Application No: CM/18/25/DOC  
Site Address: Land West of Church Lane & South of Horsemere Green Lane Climping  
Description of works: Approval of details reserved by condition imposed under reference CM/1/17/OUT relating to condition number 9 - i. surface water drainage scheme and ii. a foul water drainage scheme and condition number 10 - i./ ii. watercourses and iii. rising main and foul sewer pipe.

**Clymping Parish Council Objection CM/18/25/DOC**

Domestic Drainage Layout

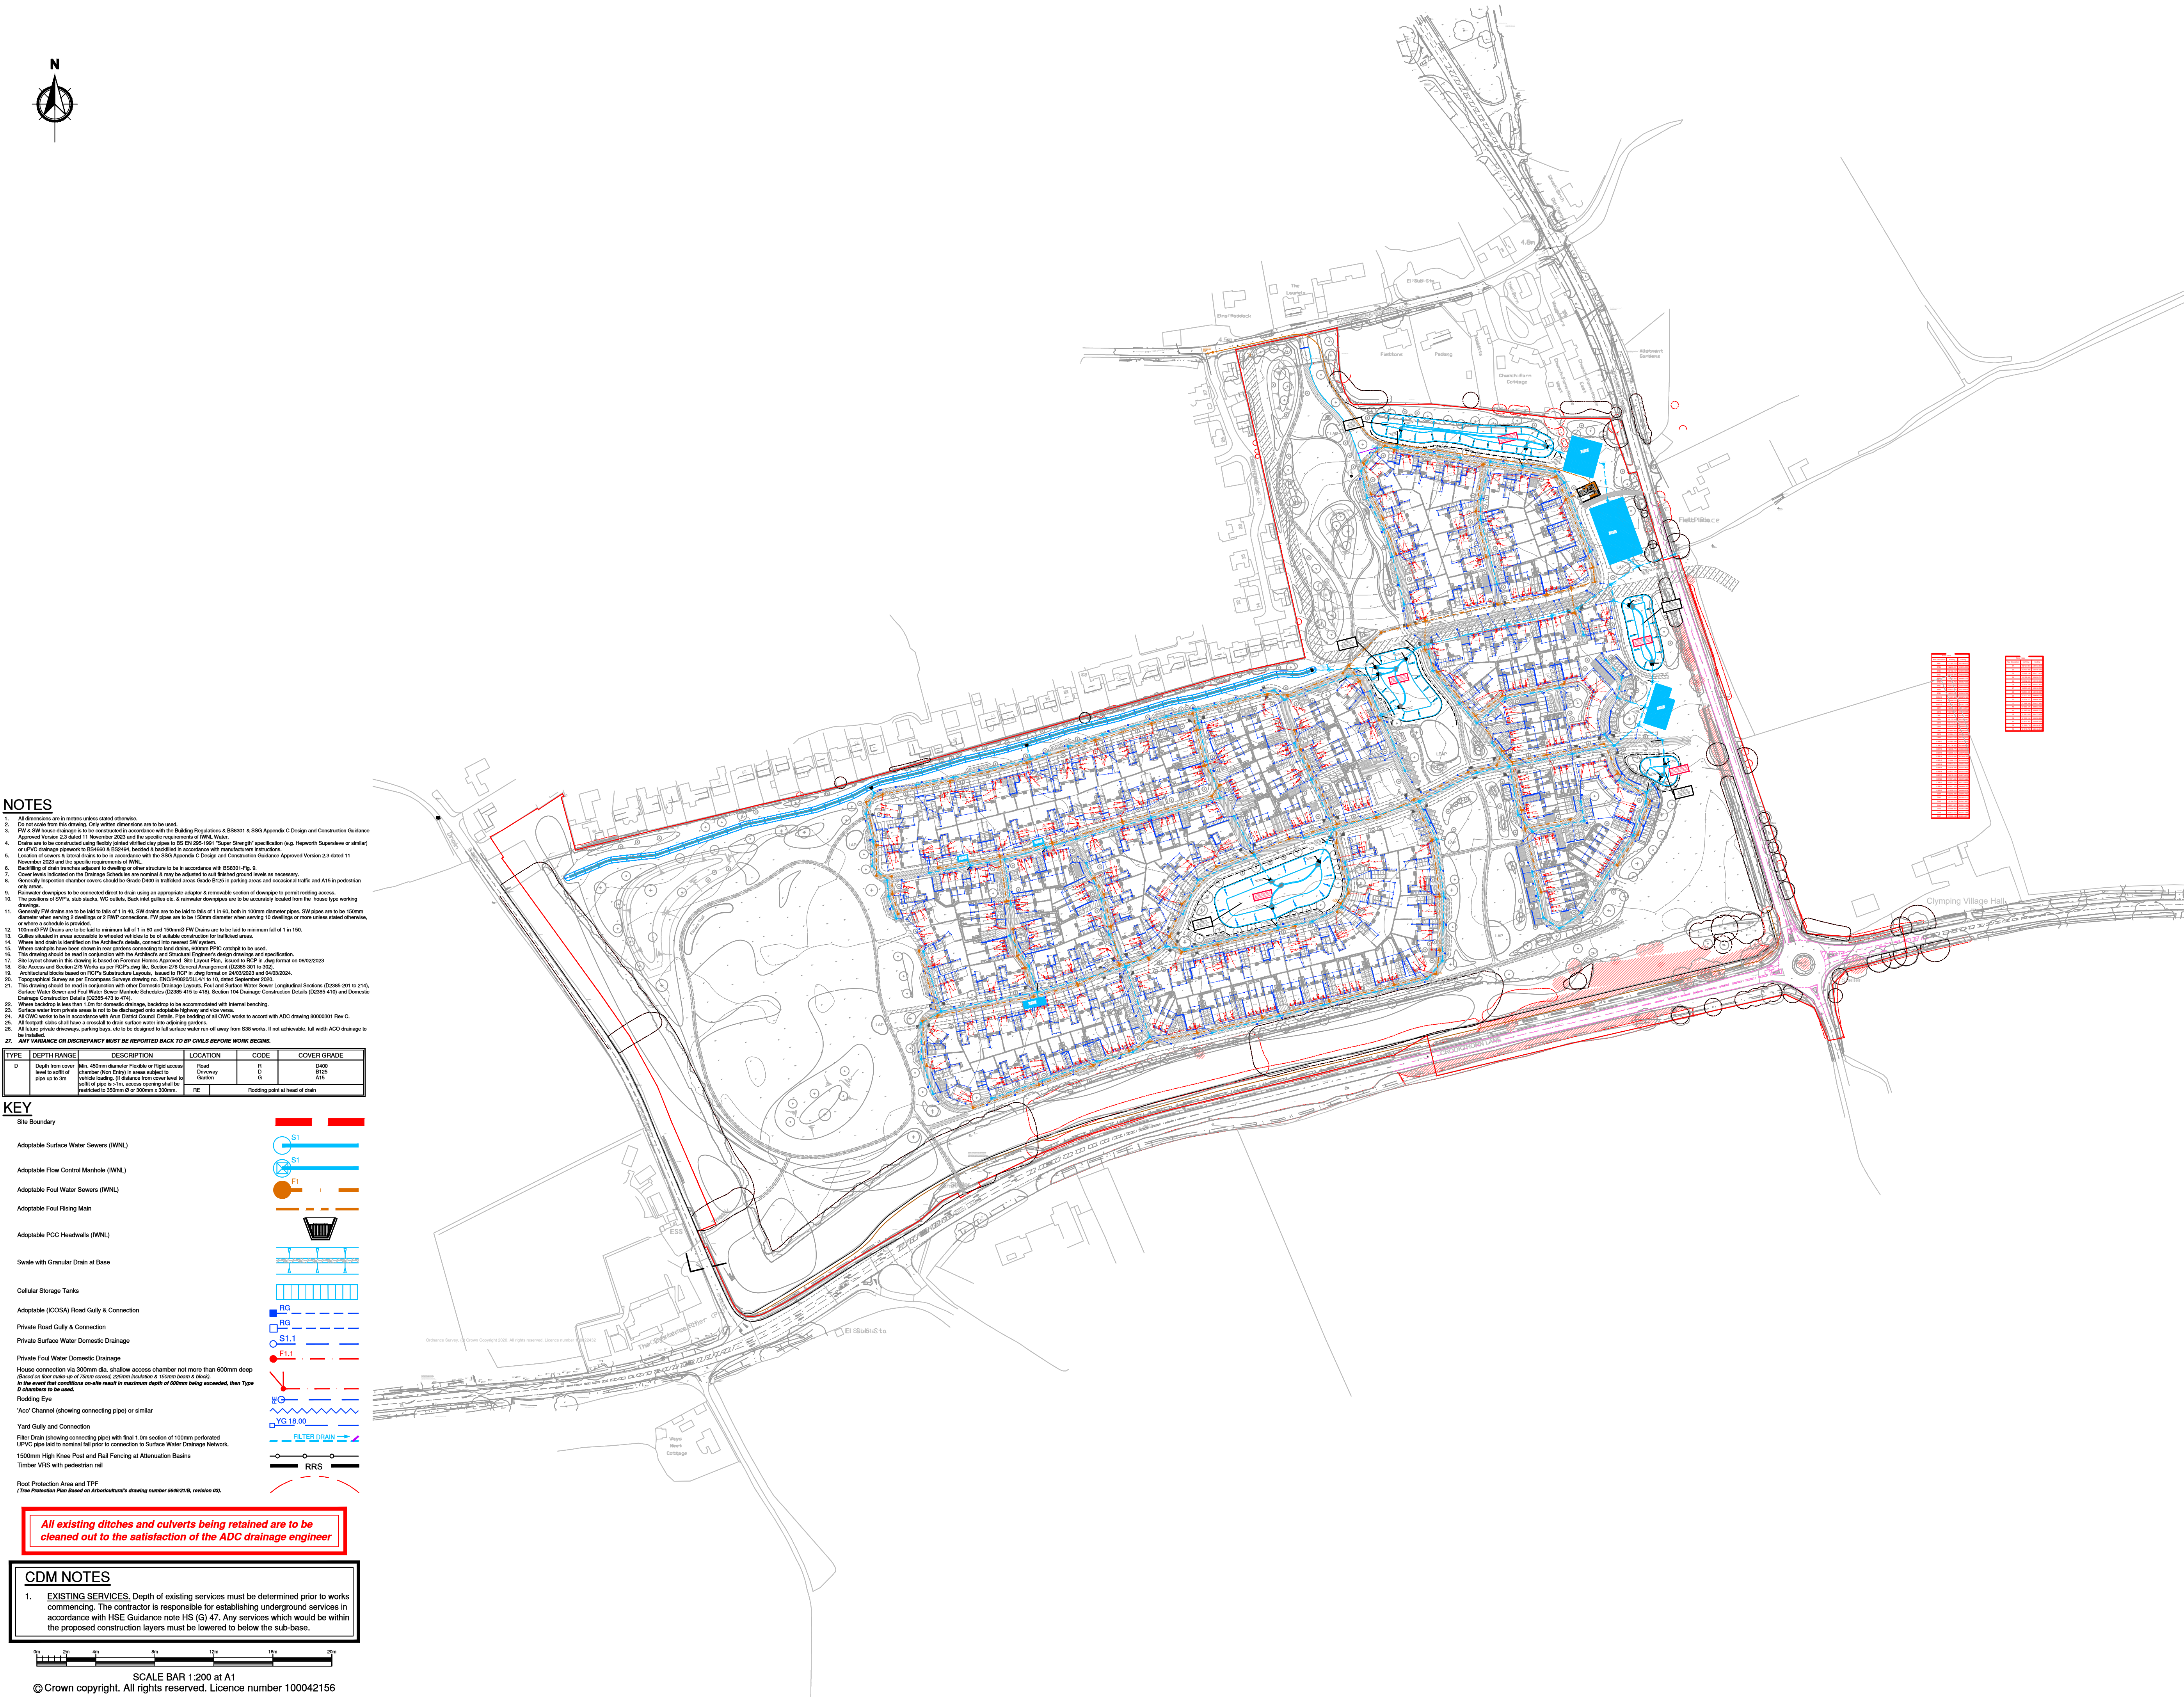
3. We note in drawings the areas marked in blue hatch for storage that apparently don't require landscaping. These areas have been virtually continuously underwater since October 2023.
